**CITY OF ALBUQUERQUE  
PLANNING DEPARTMENT  
July 20, 2011  
DRB Comments**

**PROJECT # 1008698**

**APPLICATION # 11-70186**

**RE: Lots 10 - 11, Block 68, University Heights Addition**

PLAT OF  
**LOTS 11-A, 11-B AND 11-C**  
**BLOCK 68, UNIVERSITY HEIGHTS**

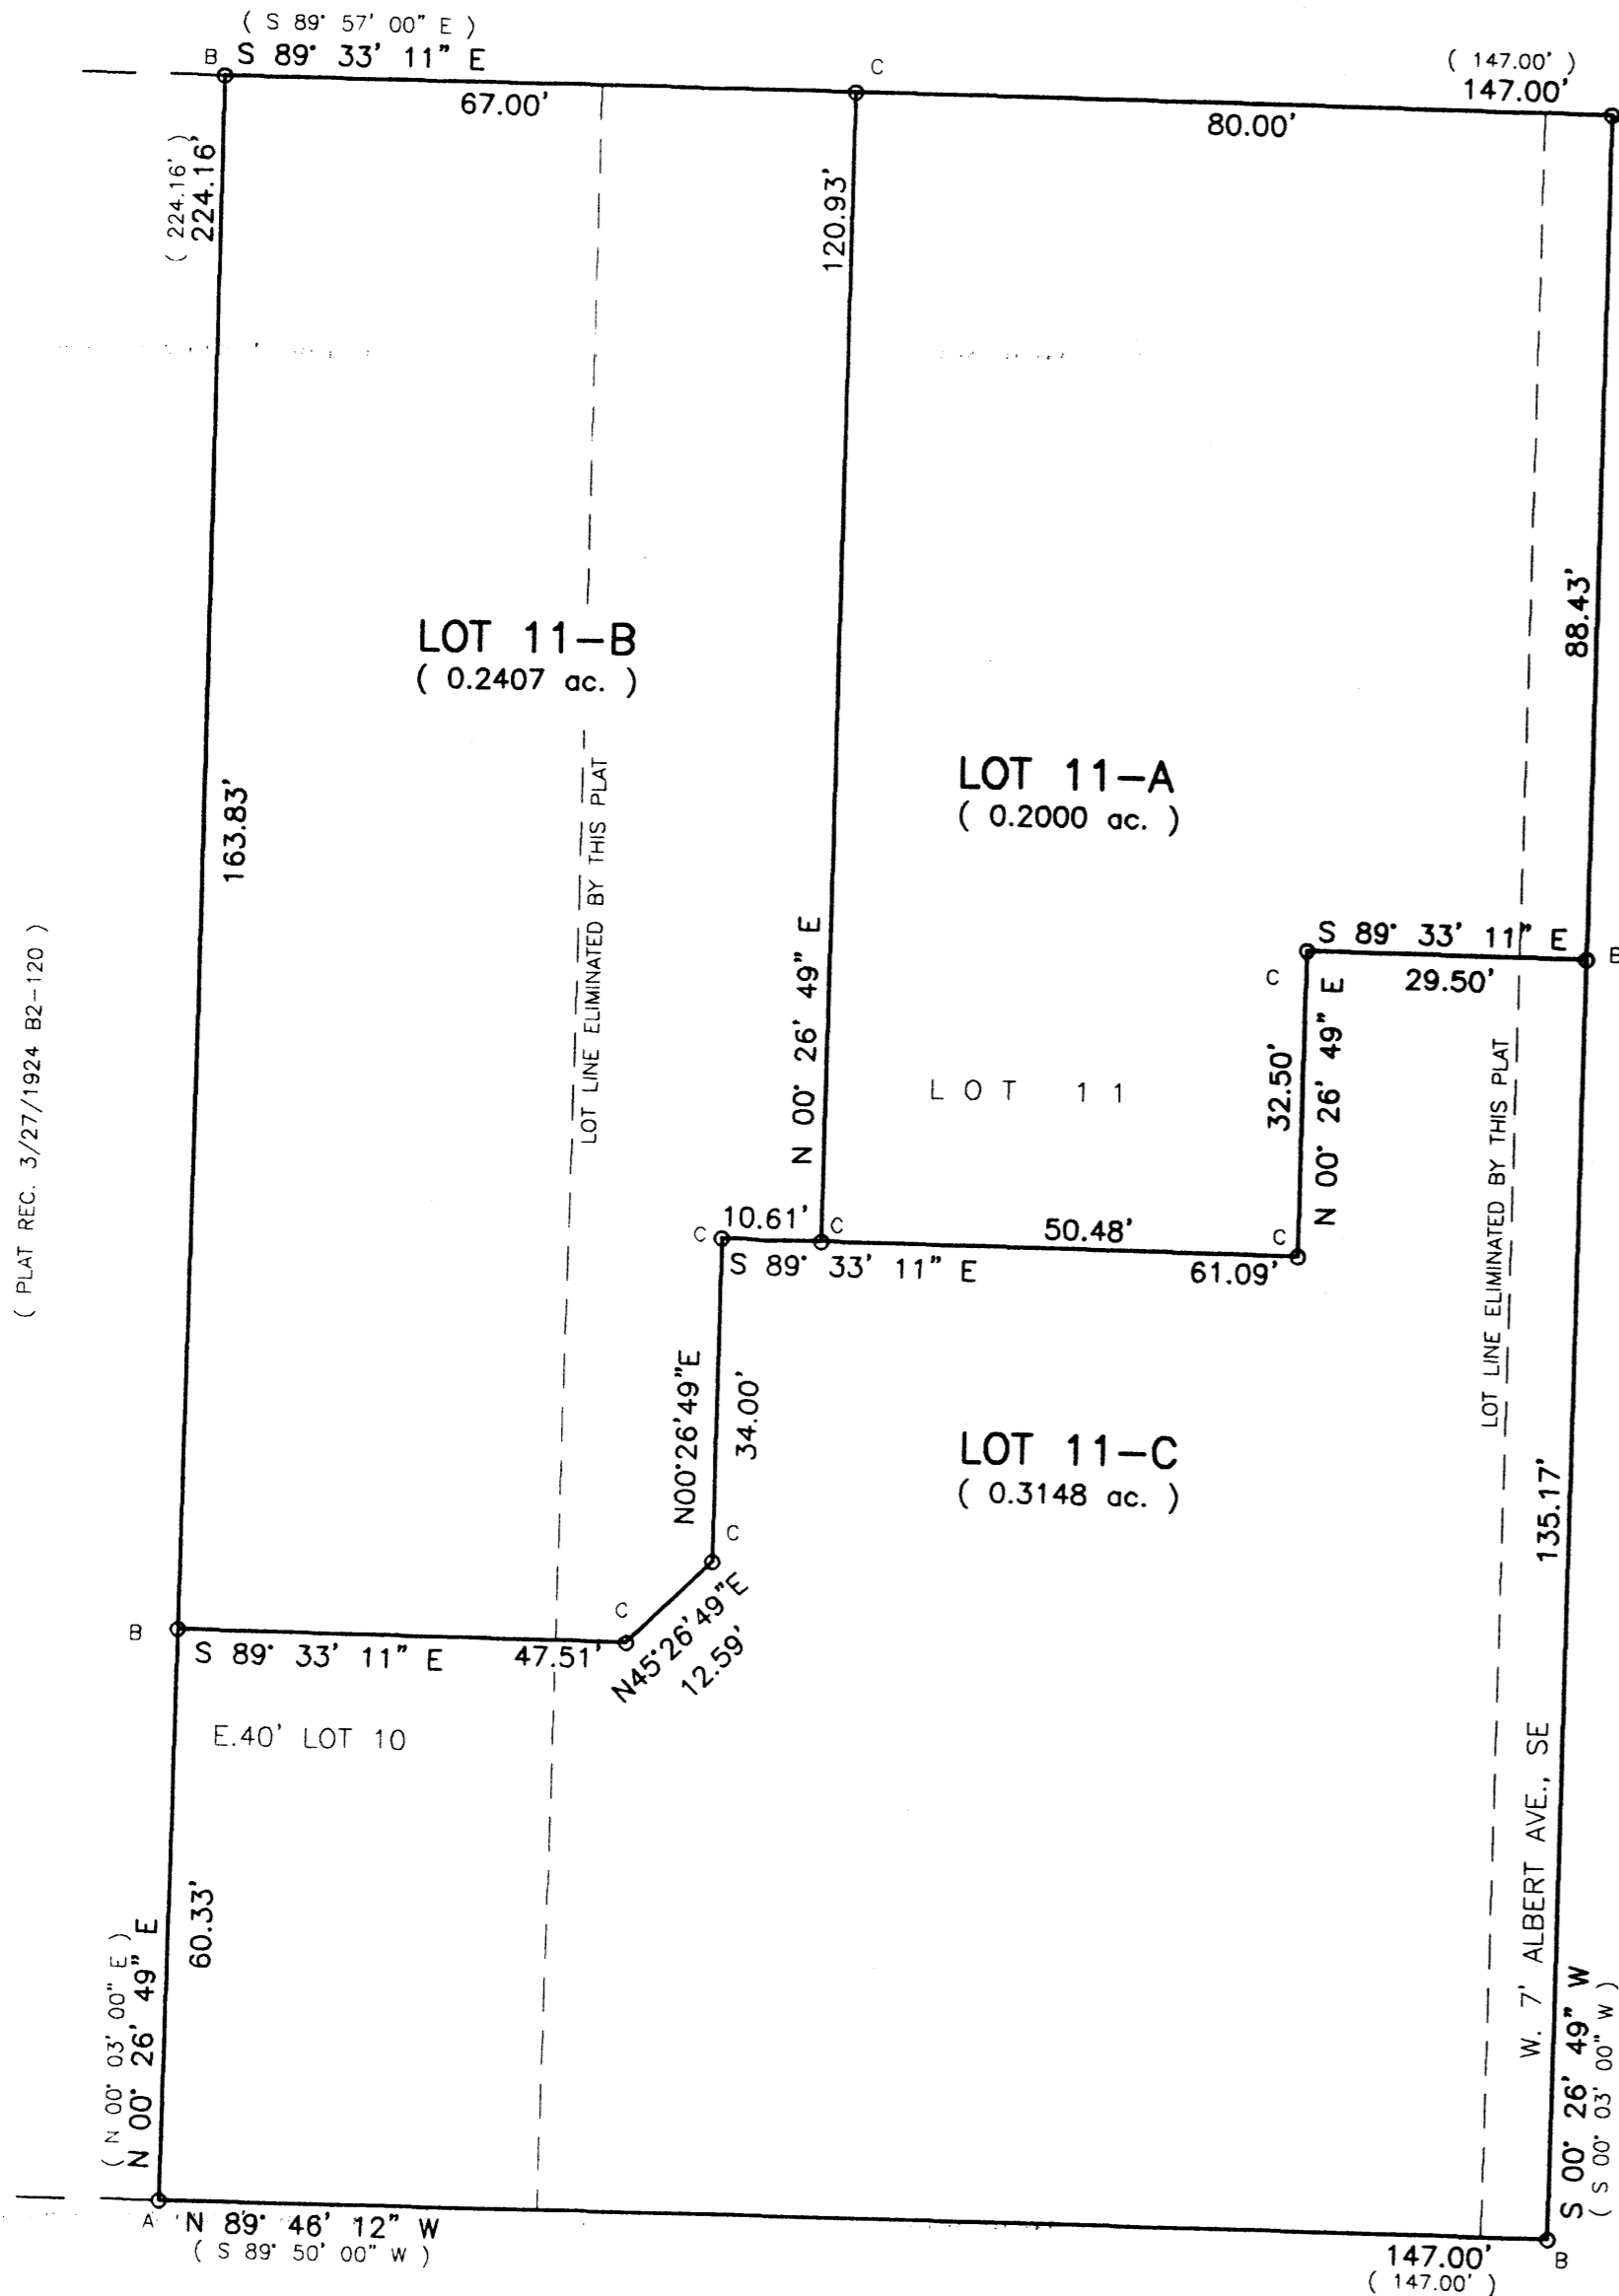
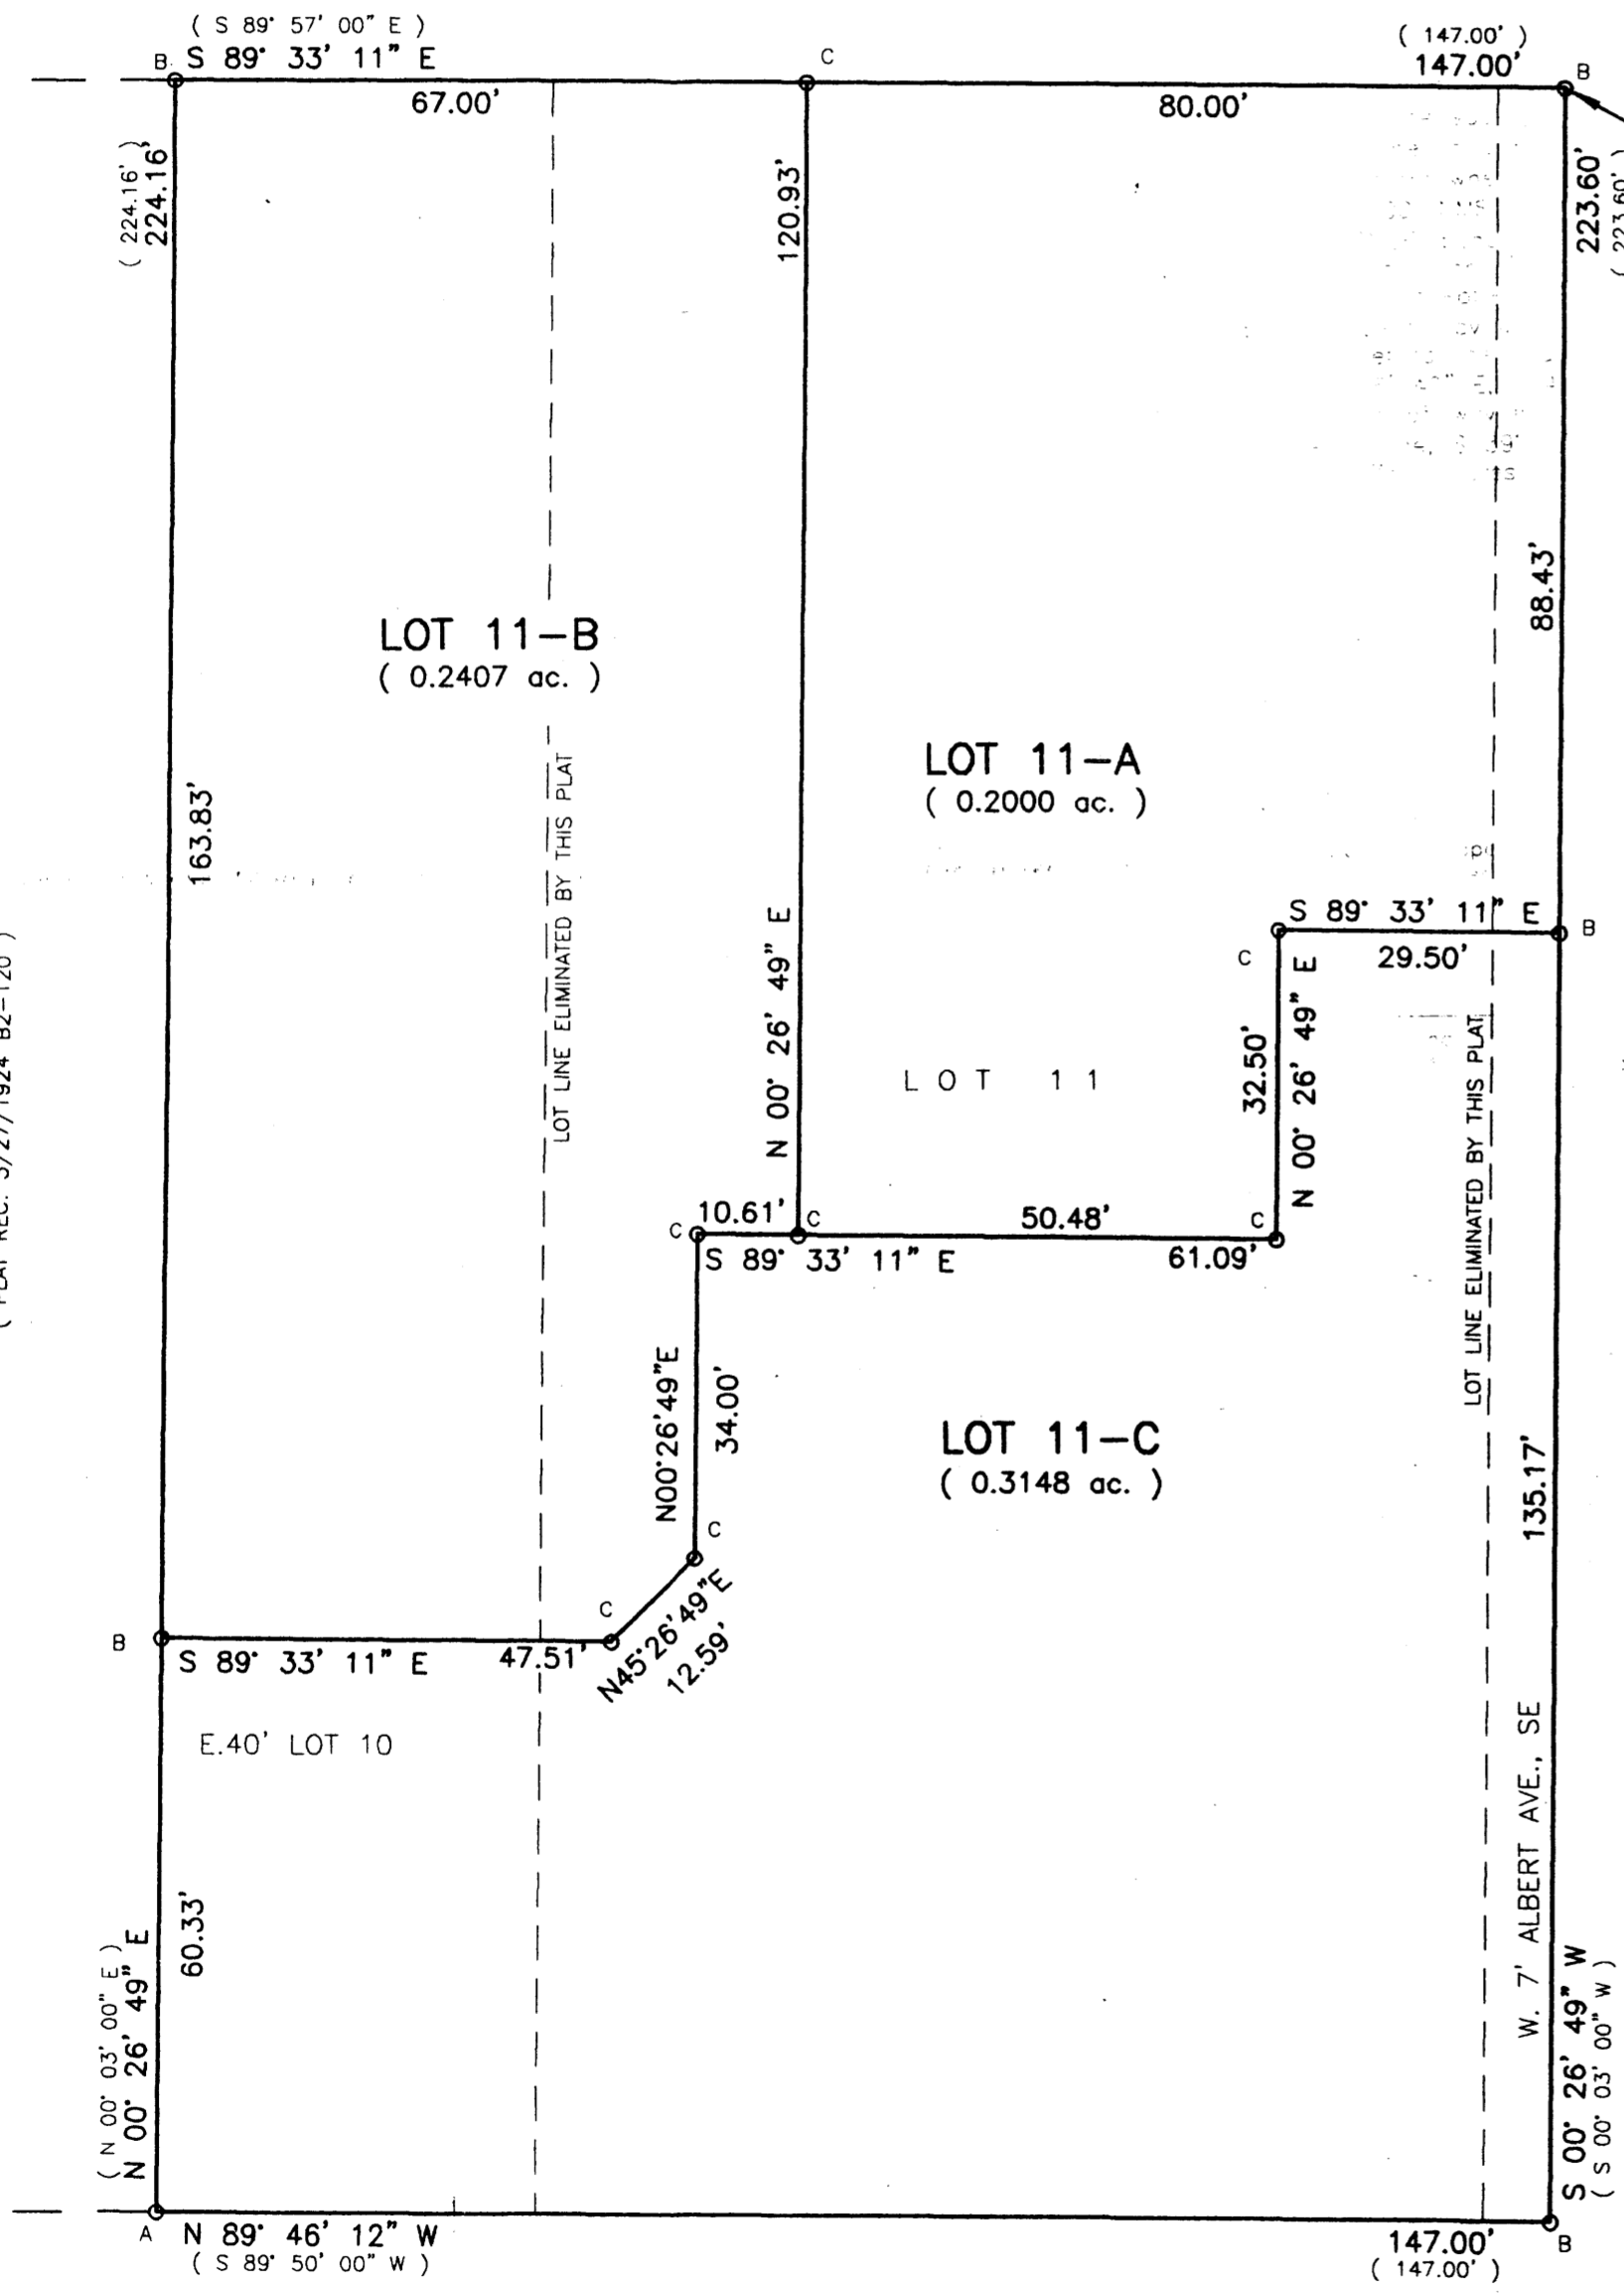
'Portions of' Lot 10 must be documented prior to 1973, or the entire lot must be included in the replat. The alley vacation must be documented and referenced on the plat.

PROPOSED SITE PLAN  
 GARFIELD OFFICE BUILDINGS  
 (2500, 2502, & 2502-A GARFIELD S.E.)  
 ALBUQUERQUE, NEW MEXICO  
 JULY, 2011

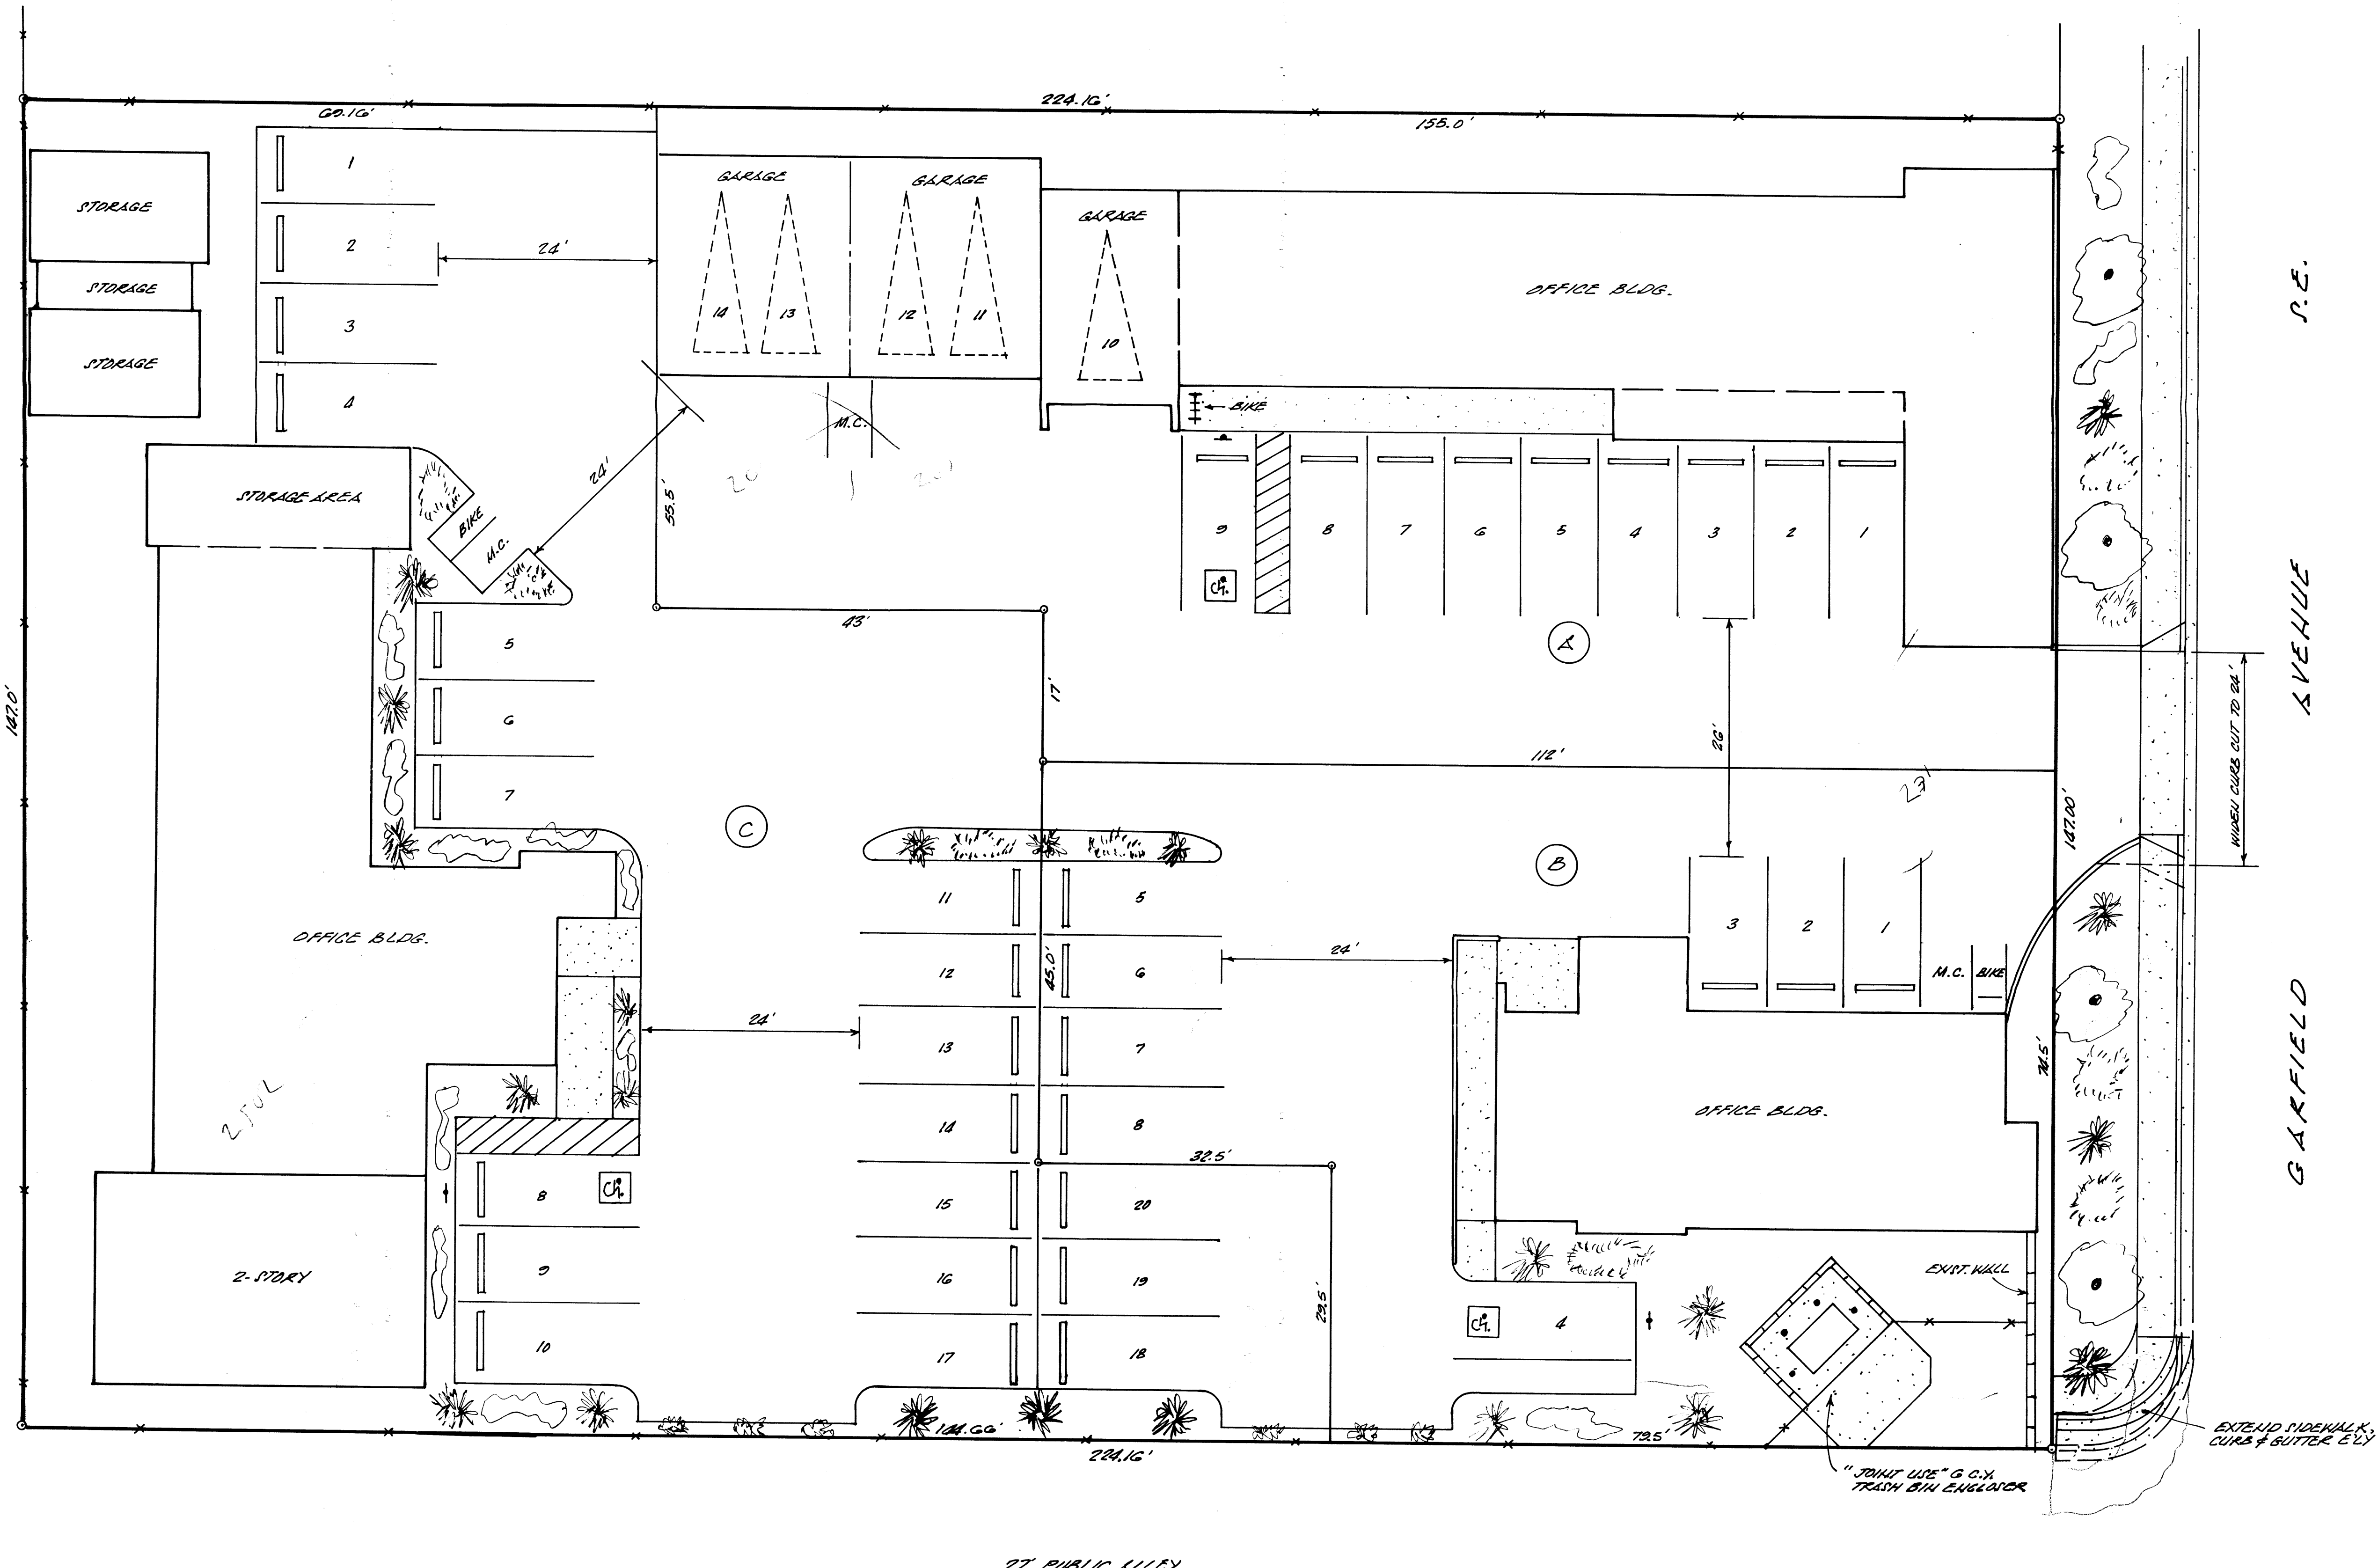
The proposed MC parking space in front of the garage of "A" would impede the vehicle spaces and would need to be removed. The garage wall would need to be certified for compliance with the Building Code for a zero lot wall.
